Your Reference: SSD 8790
Our Reference: NCA/2/2018
Contact: Maya Sarwary
Telephone: 9806 5578

SSD 8790 - Redevelopment of Parramatta West Public School

City of Parramatta Submission

1 Site Plan - Proposed
3001 1 : 500

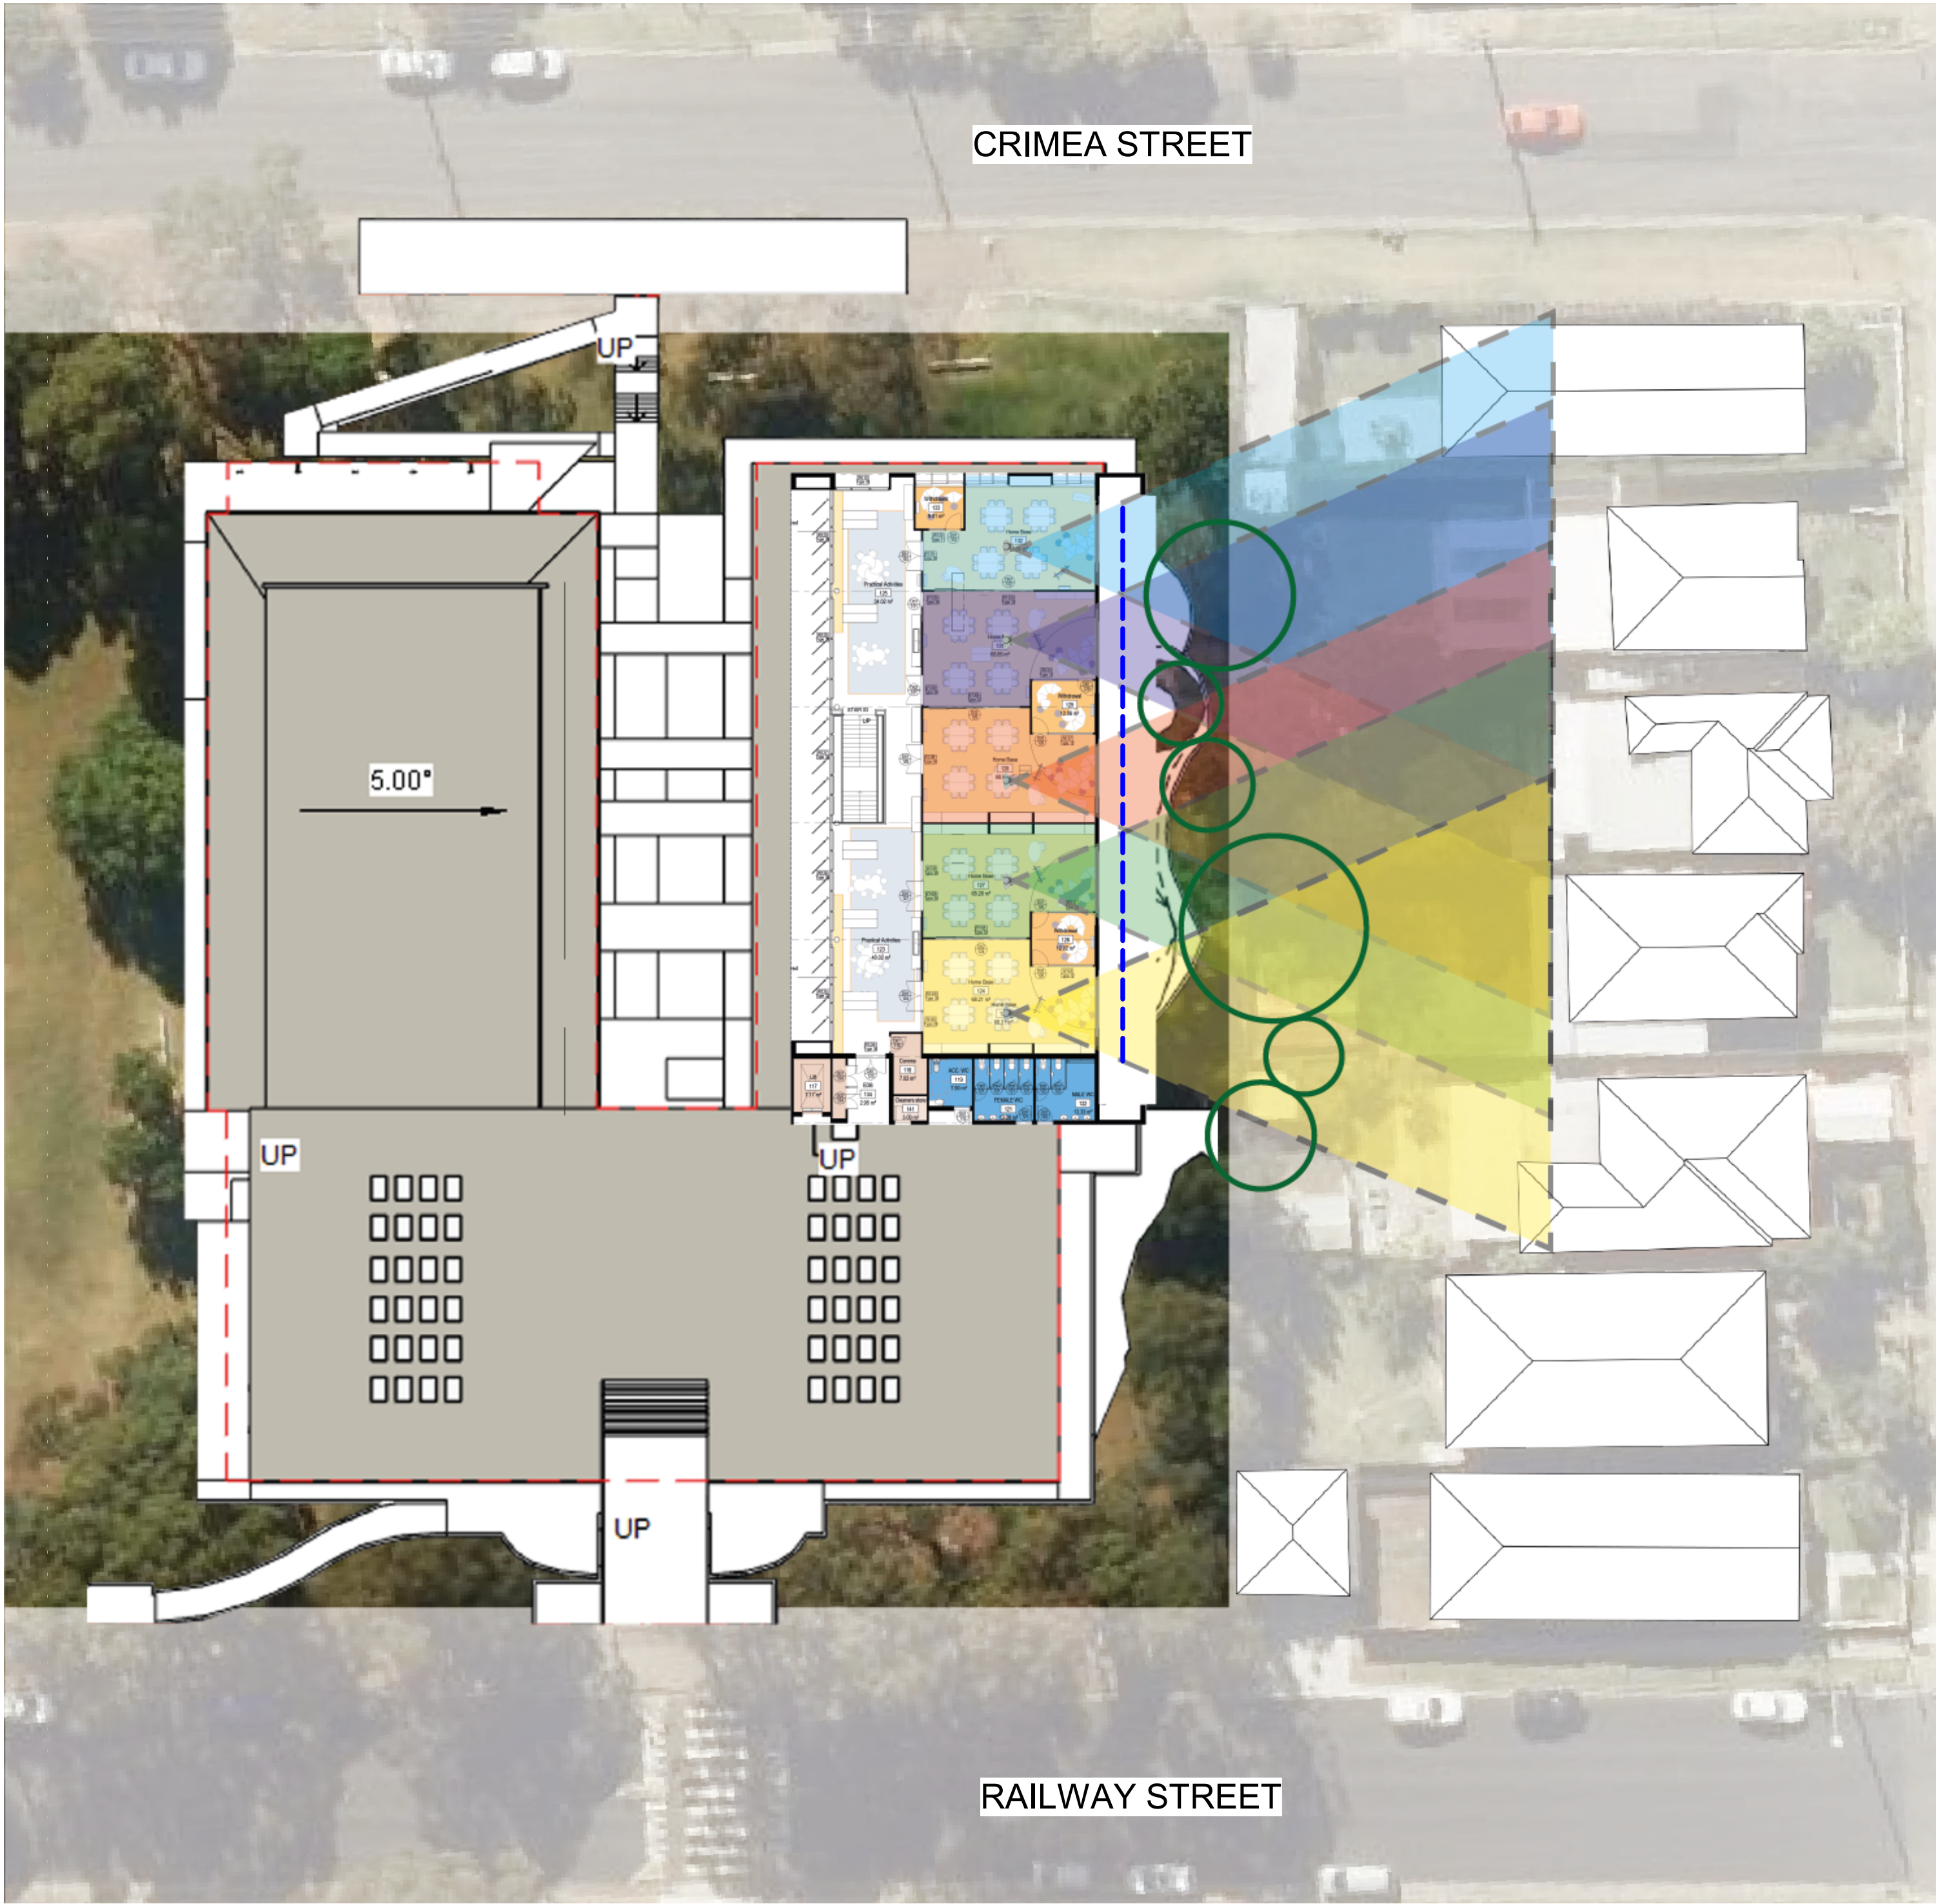
The proposed location of the new northern building will result in a significant loss of open space that is 'used as a playground during lunch and recess' and can adequately accommodate sporting and other active recreational activities. Access to the existing quantity of open space provided by the northern school site is essential for the 900+ students to be able to satisfactorily meet the physical education requirements of students consistent with the **Department of Education 'Sport and Physical Activity Policy'**. This policy requires that *"...Students in Years K-10 participate in a minimum of 150 minutes of planned moderate with some vigorous physical activity across the school week"*. The significantly reduced open space within the school will have inadequate capacity to accommodate physical activity requirements of the large volume of students during school hours.

Whilst it is acknowledged that the school would need to continue to operate whilst the new facilities are under construction, the existing demountable buildings could be temporarily relocated into the northern open space site during works. This would allow for the required new educational facilities to be incorporated into the southern site and enable retention of northern site as open space, providing for a significantly better outcome that is more consistent with applicable planning provisions, policies and strategies.

- i. *Revise the Social Impact Assessment to reflect Council's draft Social Infrastructure Strategy and more adequately address the loss of open space provision within the school.*
- ii. *Incorporate new buildings into the southern site and retain existing northern site as open space consistent with the Central City District Plan (Planning Priority C17), Health Urban Development Checklist (PA3) and Design Guide for Schools (Principle 5).*

NORTH BUILDING -
NORTH AND SOUTH
ELEVATIONS

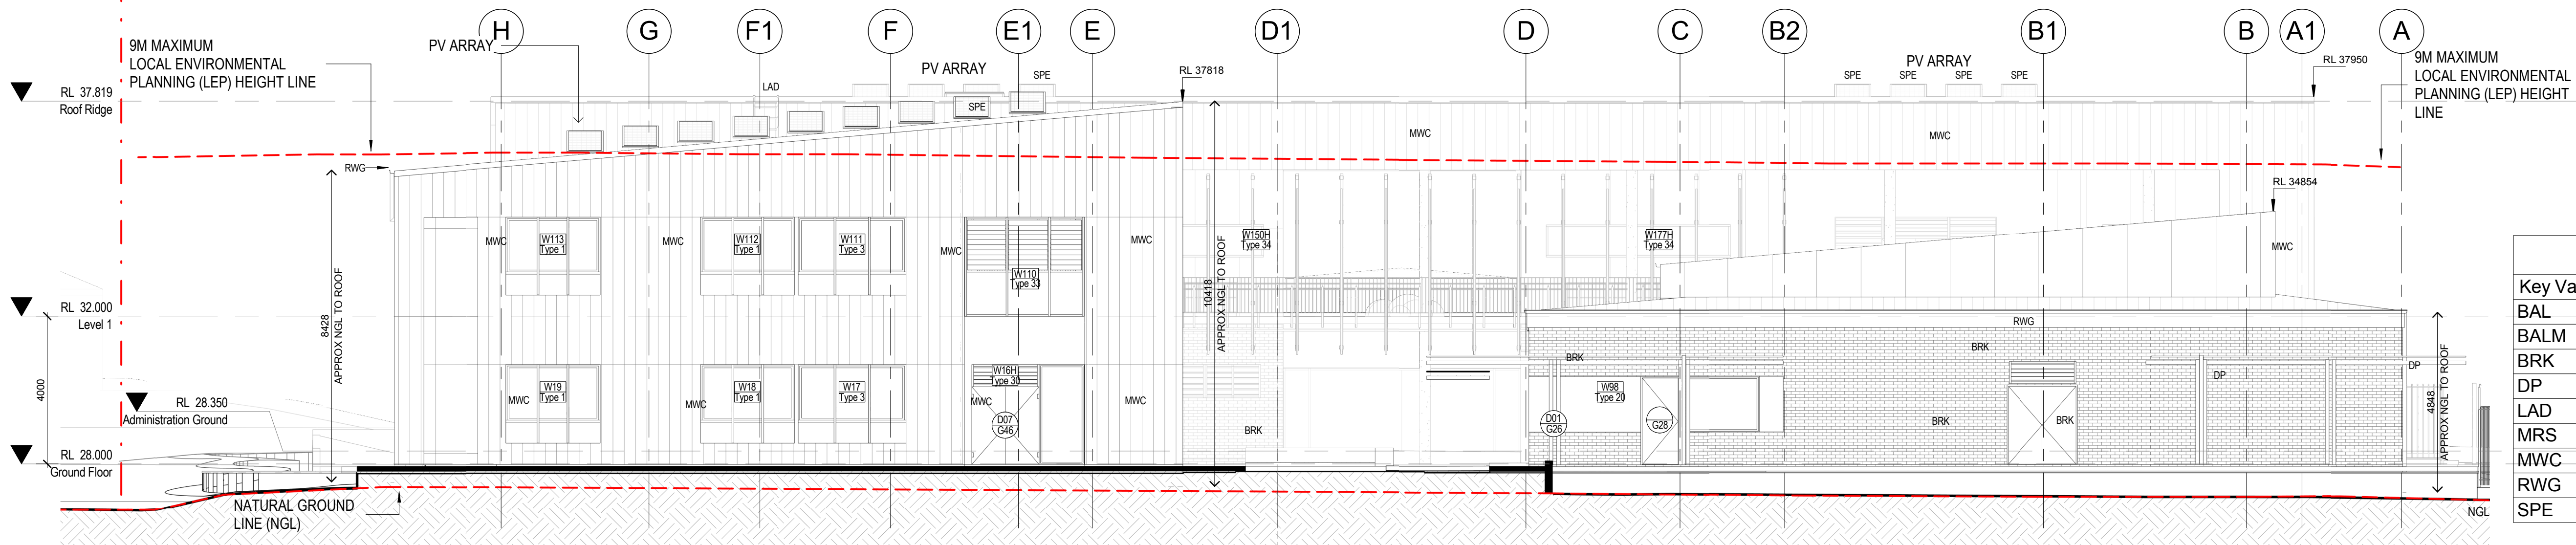
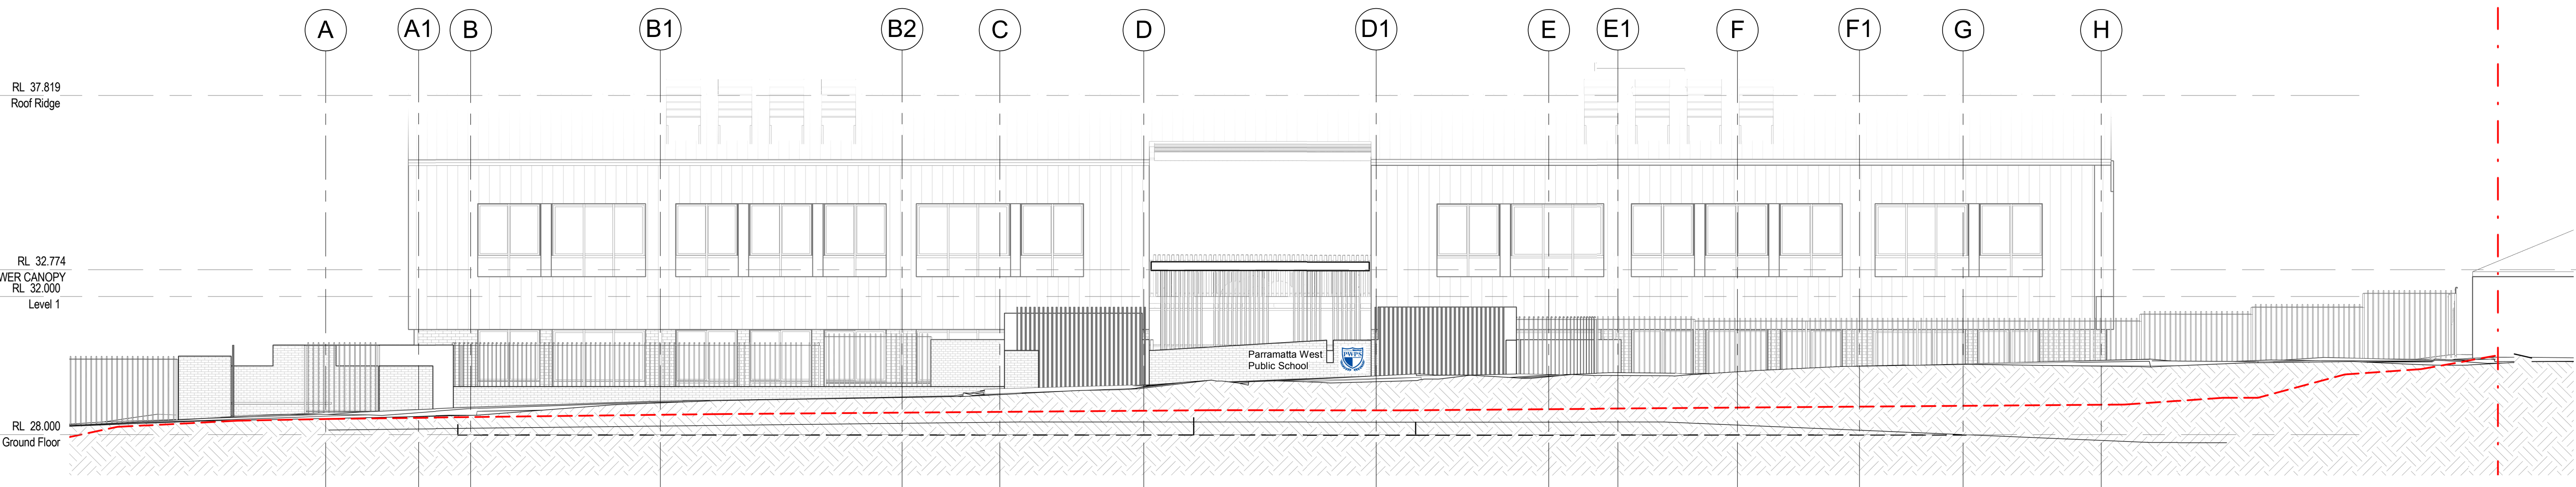
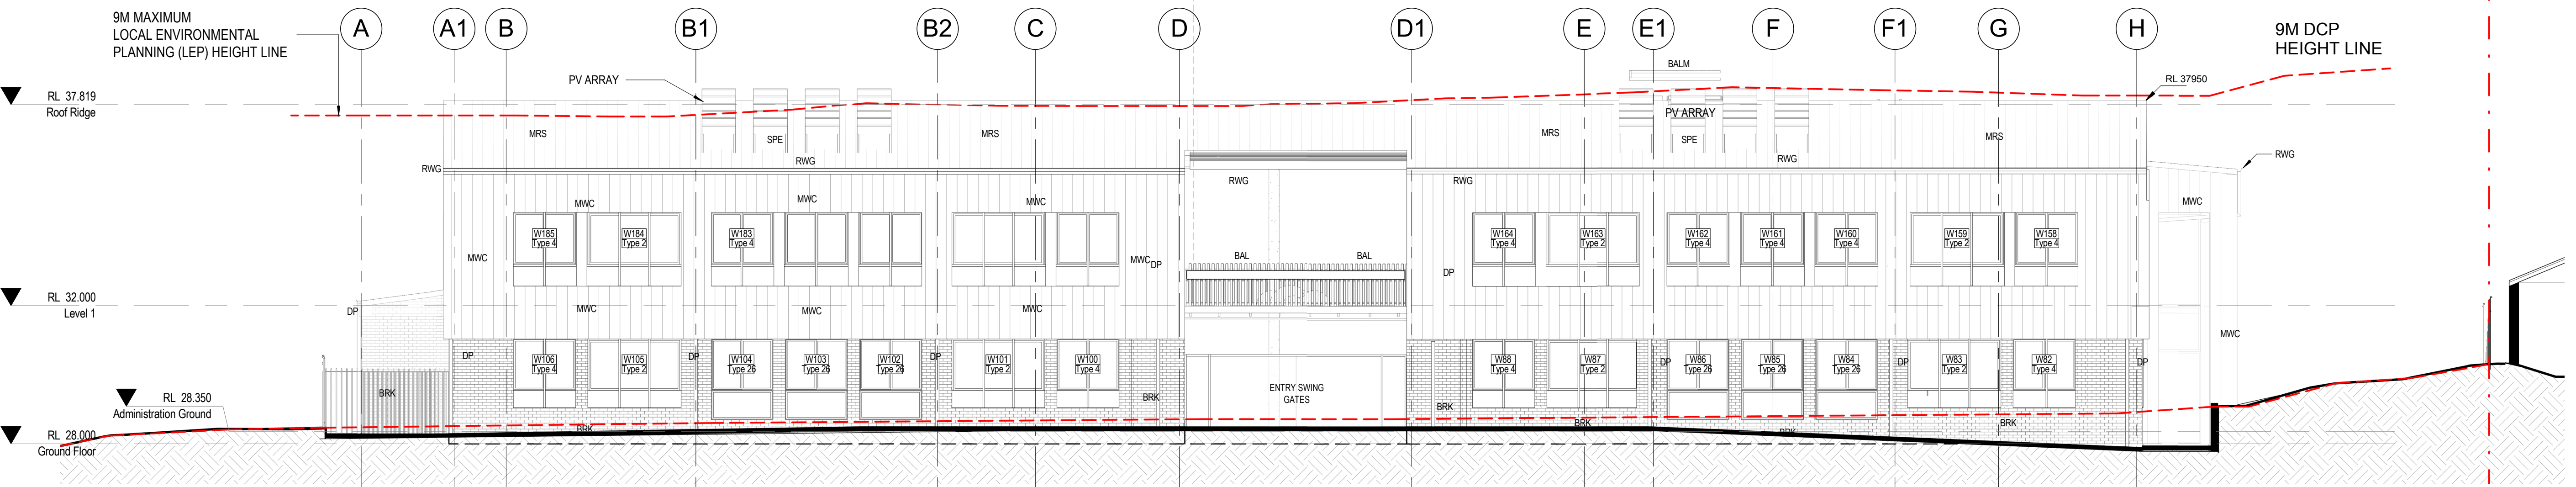
- The proposed new building has in some respects an industrial aesthetic. This is at odds with the predominant residential aesthetic of the existing school buildings (in particular the historic school buildings) and of the surrounding low density residential area. Modulation of the façade should be provided to reduce bulk, breaking roof planes into smaller areas, use of design features to provide fine grain visual interest, materials that are not industrial in character, windows set on the inside face, and appropriate colours.

- The scale of the building is considerably larger than that of the existing school buildings and is at odds with the scale of surrounding development. The bulk of the building should be reduced, in particular the scale of the Franklin Street façade.

The height of the development exceeds the maximum 9m height control stipulated by the Holroyd Local Environmental Plan 2013.

In order to minimise adverse impacts on the streetscape and on adjoining residential properties the height of the development should comply with the 9m maximum control applicable to the site.
